Statement of Response to An Bord Pleanála Opinion in respect of the proposed

Kilbarry SHD, Cork

Prepared in June, 2022 on behalf of

Cork County GAA Board

Drawing file: Engineering / 5 Proposed Junction Sightlines.pdf

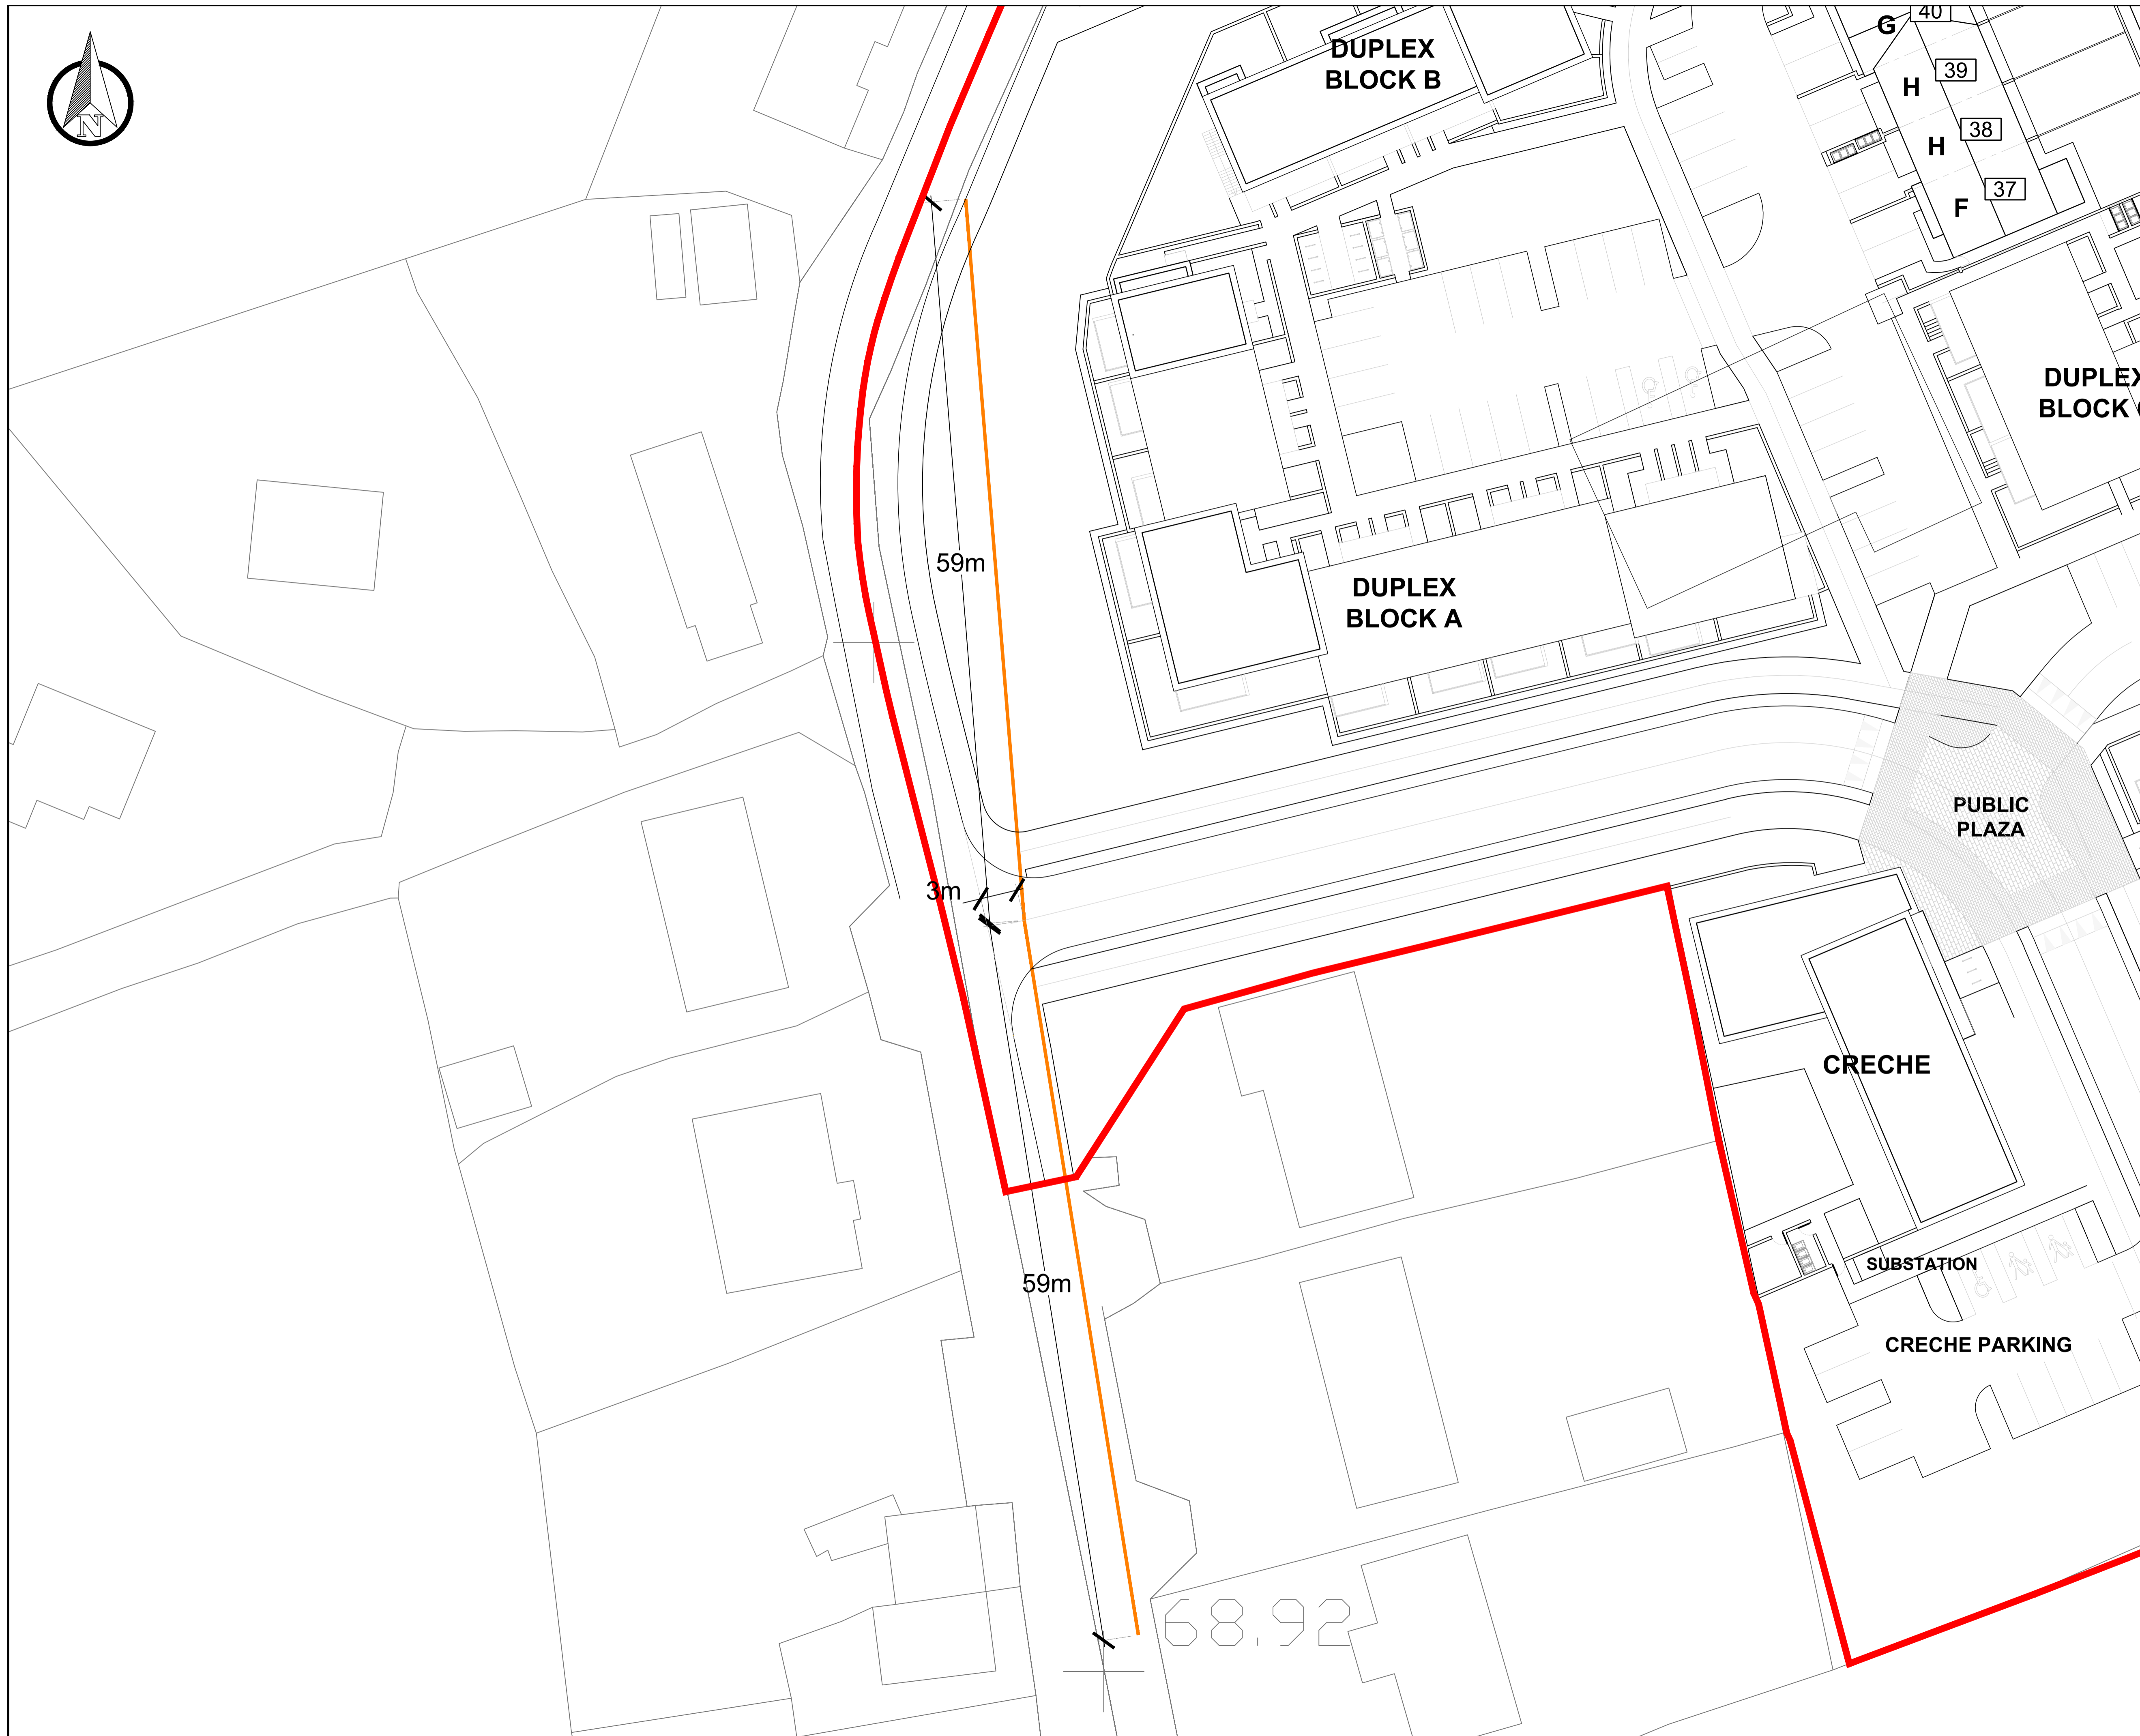
4. Further consideration, and possible amendment to the documents in respect of the relationship of the proposed development with the Old Whitechurch Road. Consideration should be given to the design of the junction with the proposed distributor road demonstrating that adequate sightlines can be achieved at this location. In addition, the accommodation of pedestrian / cycle movements from the development and from the public to the Old Whitechurch Road and connections to the footpath network in the area should be fully considered. This may require amendment to the documents and / design proposals submitted.

Sightlines at the Old Whitechurch Road entrance will be provided in accordance with DMURS. The Old Whitechurch Road here is within a 50kmh speed limit and therefore a design speed of 60kmh applies. In accordance with section 4.4.4 of DMURS, sightlines of 59 meters are required. See Drawing No. 19215-JBB-00-XX-DR-C-05001 prepared by JB Barry Consulting Engineers, for sightlines at the junction.
